ADDENDUM NO. 1, APRIL 14, 2009

RE: Ocean Avenue Elementary School
Portland, Maine
A/E Comm. No. 3316.10

City of Portland RFP No. 7109
BGS project No. 723

Drawing file: Vol-02-Stamped / 008-EY-101-A.PDF

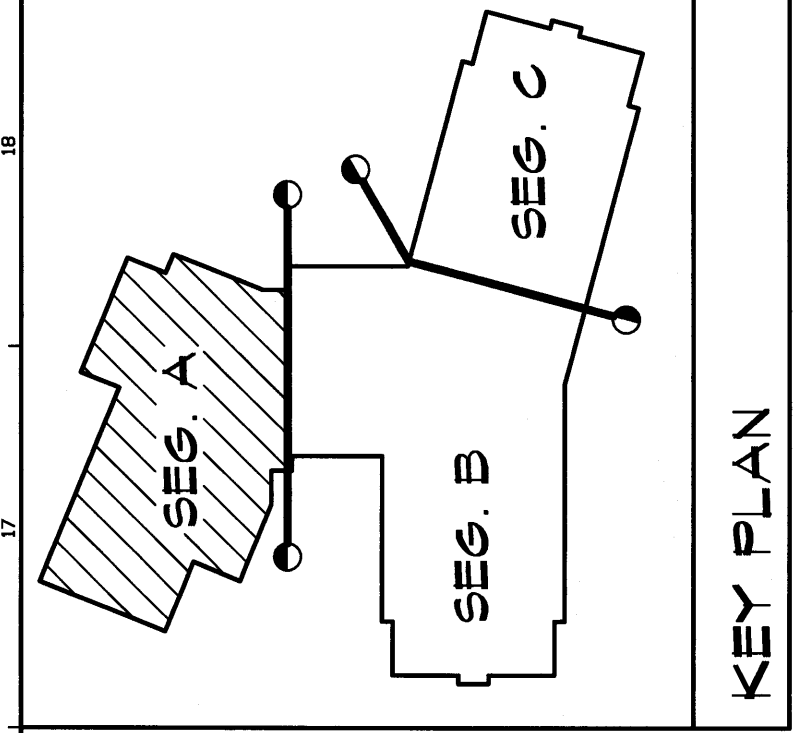
24. Sheet EP101-B, First Floor Electrical Power Plan – Seg. B, REVISE portions as indicated on Sketch ADD1-EP101-B-1.
25. Sheet EY101-A, First Floor Systems Plan – Seg. A, REVISE portions as indicated on Sketch ADD1-EY101-A-1.
